CITY OF ALBUQUERQUE

July 28, 2021

**Re: Carlisle Crossing – 2100 Carlisle NE
Erosion and Sediment Control Plan
Engineer's Stamp Date 7/27/2021 (H17E097)**

TEMPORARY EROSION AND SEDIMENT CONTROL PLAN

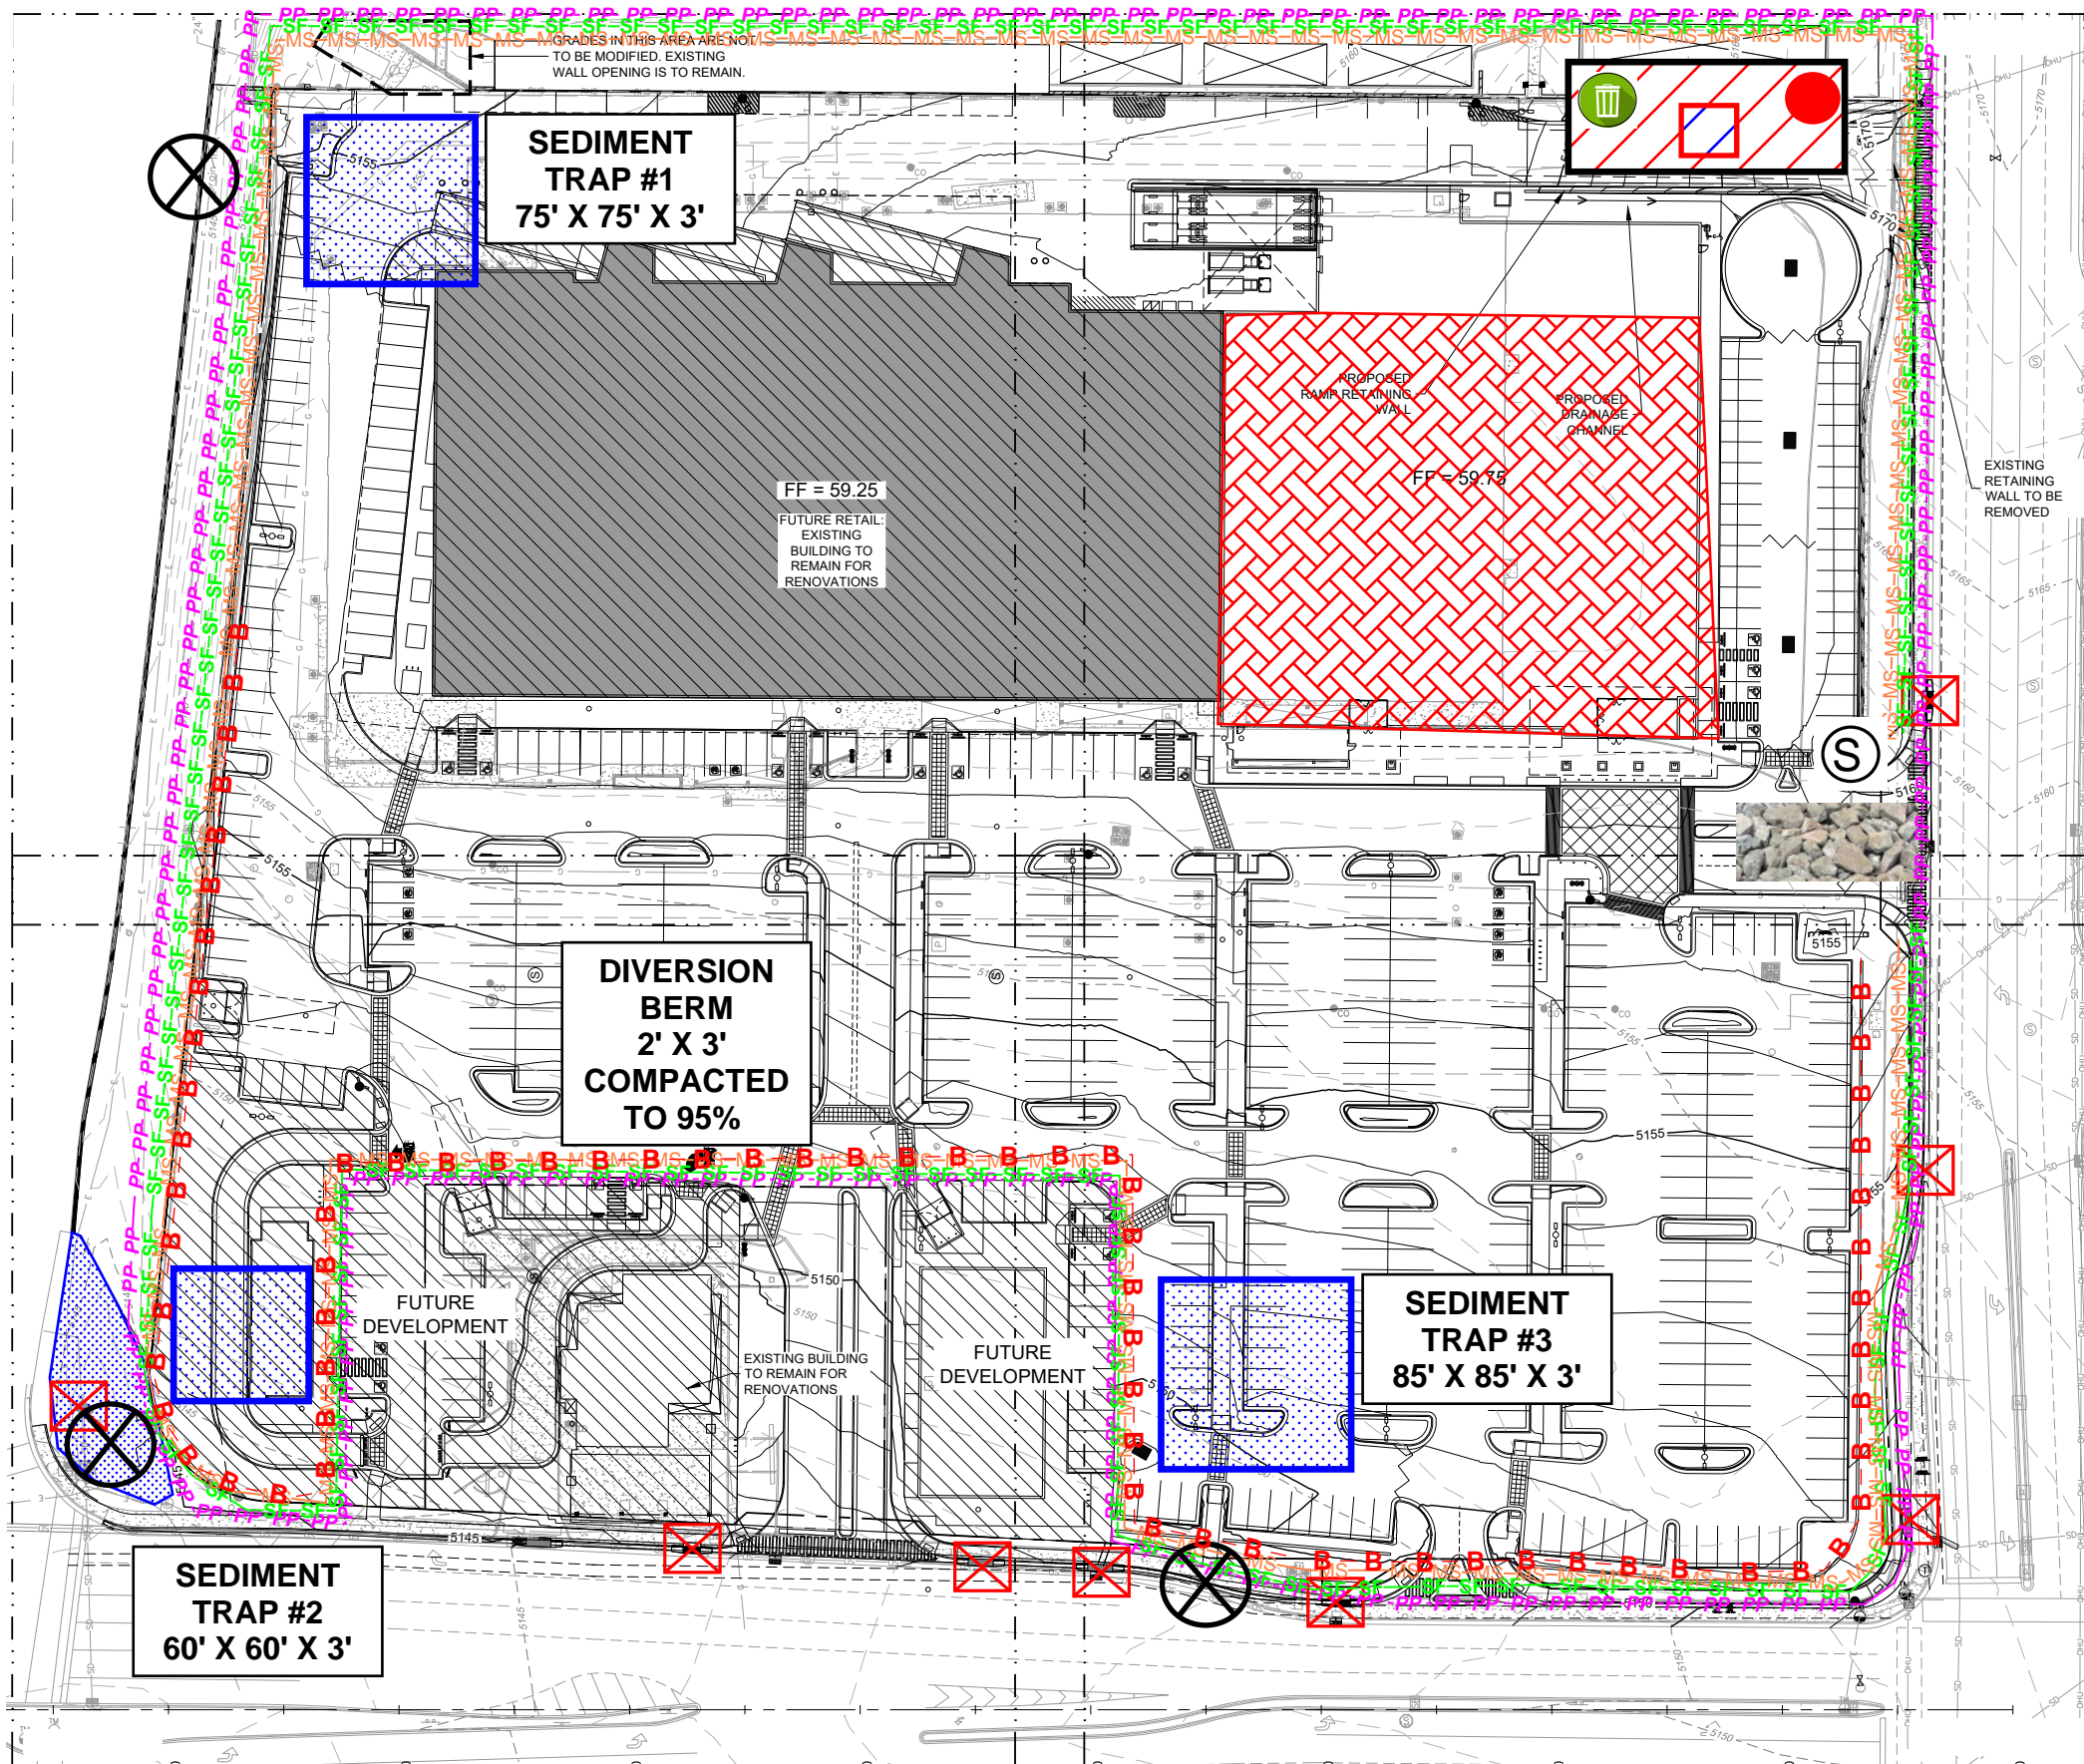
1. The ESC Plan can't be approved for Grading, Building Permit, or Work Order until the Grading and Drainage Plan is approved by hydrology for each of those purposes. An individual plan may be provided for each goal. The existing and proposed grades must be shown on the plan, and they must agree with the Grading Plan approved by Hydrology (CGP7.2.4.b.ii);

3. Number the sheets indicating each sheet number and the total number of sheets in the ESC Plan. For example this four page ESC Plan would be numbered Sheet 1 of 4, 2 of 4, 3 of 4, and 4 of 4.

4. Soil information – add a table with name type, particle sizes, and Erodibility factor (CGP 2.1.1).
5. Update the engineer's stamp date each time the plan is changed.
